**DELEGATED DECISION FOR APPLICATION FOR CERTIFICATE OF
LAWFUL DEVELOPMENT**

Reference no.: 2024/CL/91679/W

Site: 37, St Mary's Avenue, Netherthong, Holmfirth,
HD9 3XN

Description: Certificate of lawfulness for proposed erection of
single storey rear extension and associated alterations

1 Proposed Ground Floor Plan
Scale: 1:50

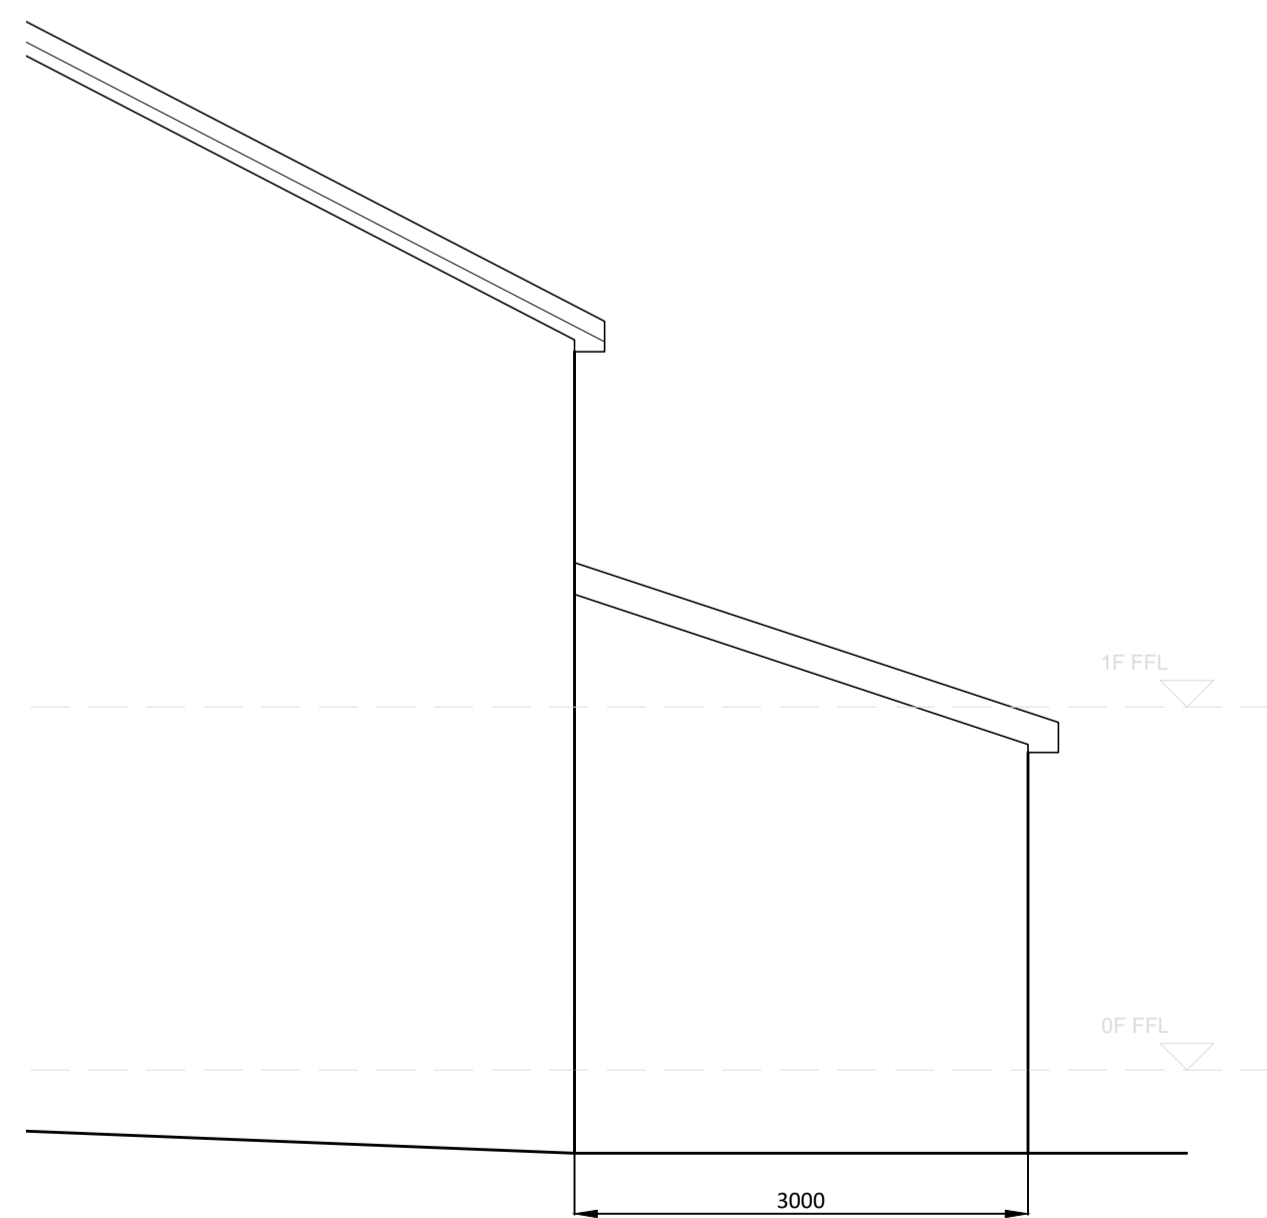
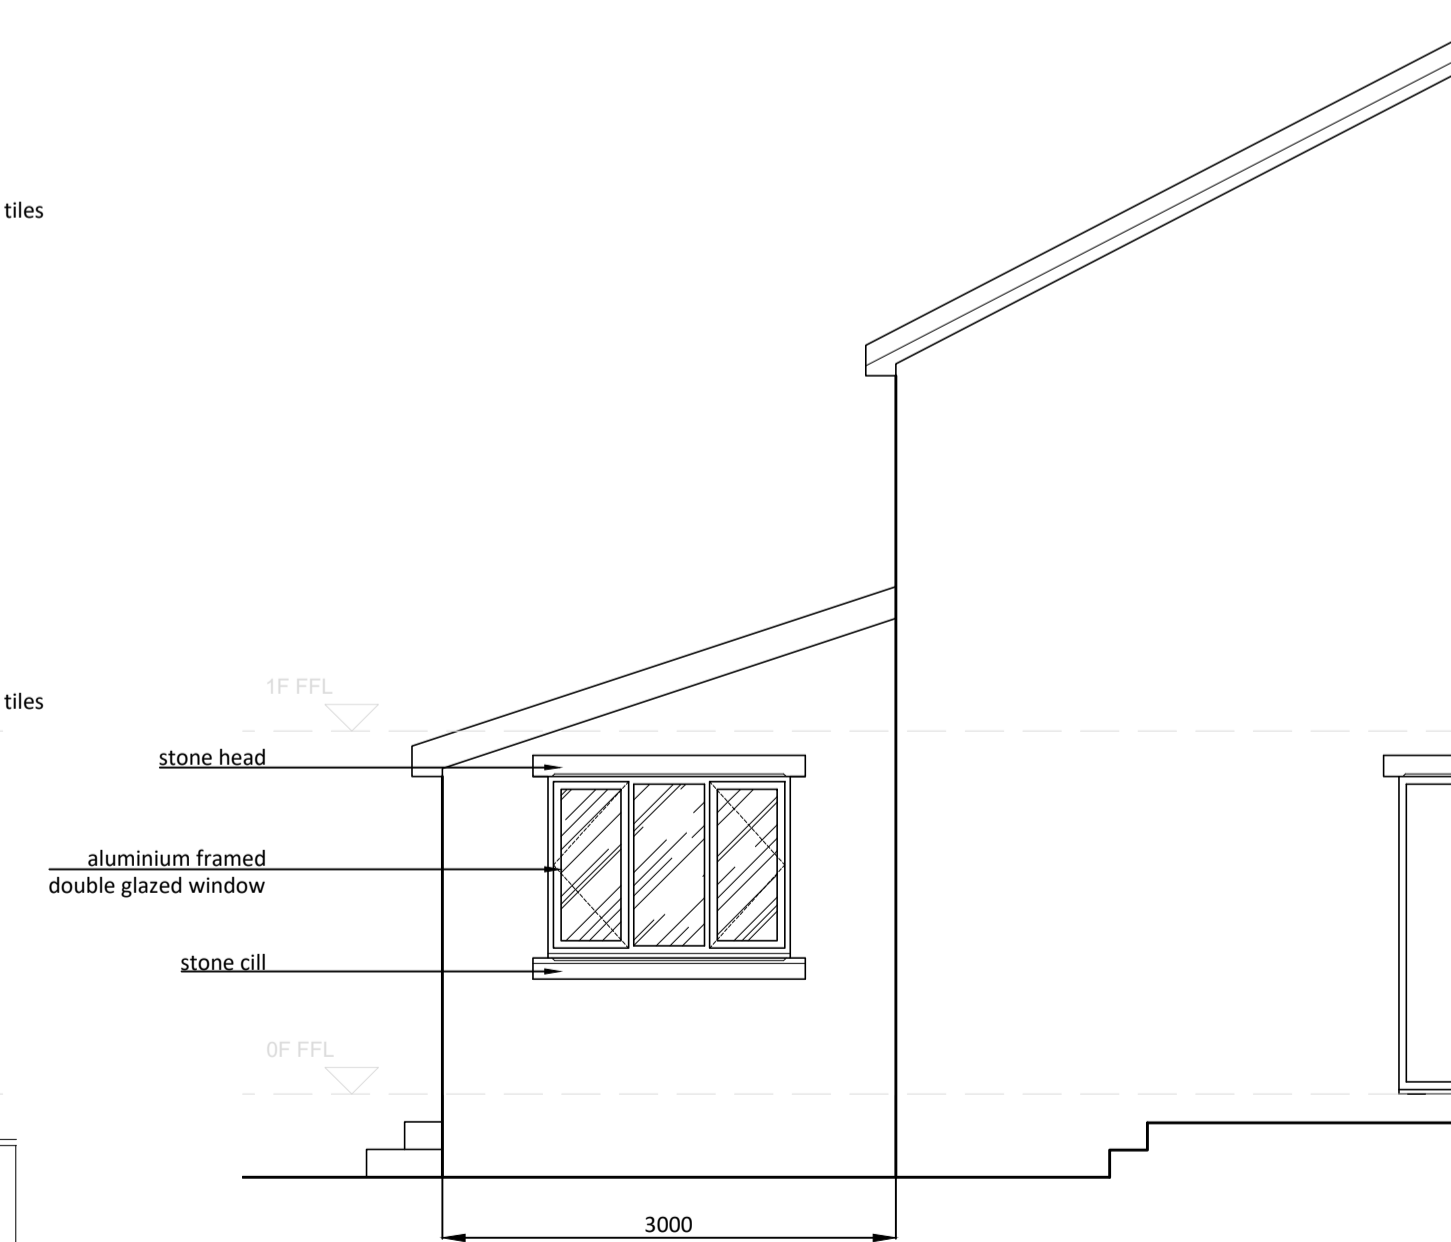
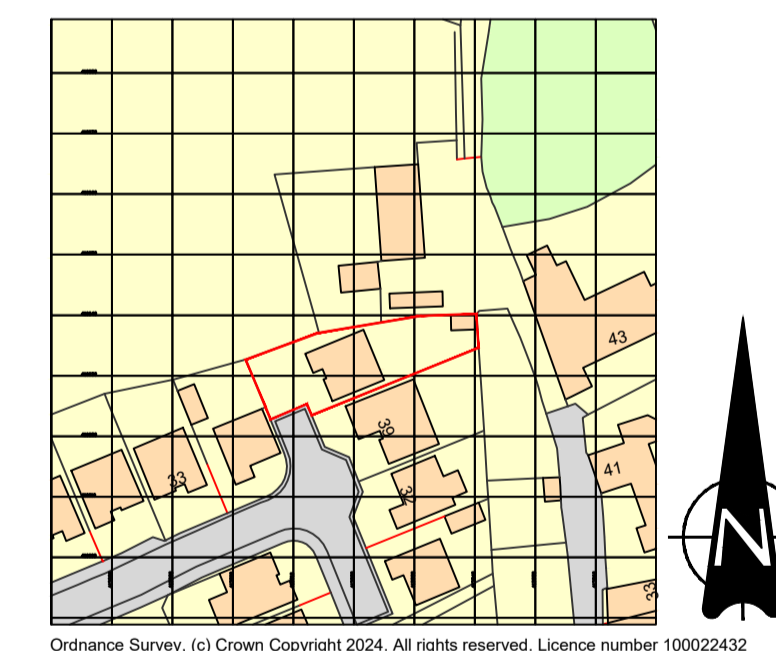
The extension would project from the rear elevation of the property by 3 metres and would be a total length of 5.9 metres with an eaves height of 2.8 metres rising to an overall height of 3.9 metres to the ridge.

Comment: *The dwelling is a detached property and the extension would not project beyond the rear wall of the original dwellinghouse by more than 4 metres. It would not exceed 4 metres in height.*

Comment: *The extension is within 2 metres of the boundary of the curtilage of the dwellinghouse but the eaves of the enlarged part would not exceed 3 metres (2.8 metres proposed).*
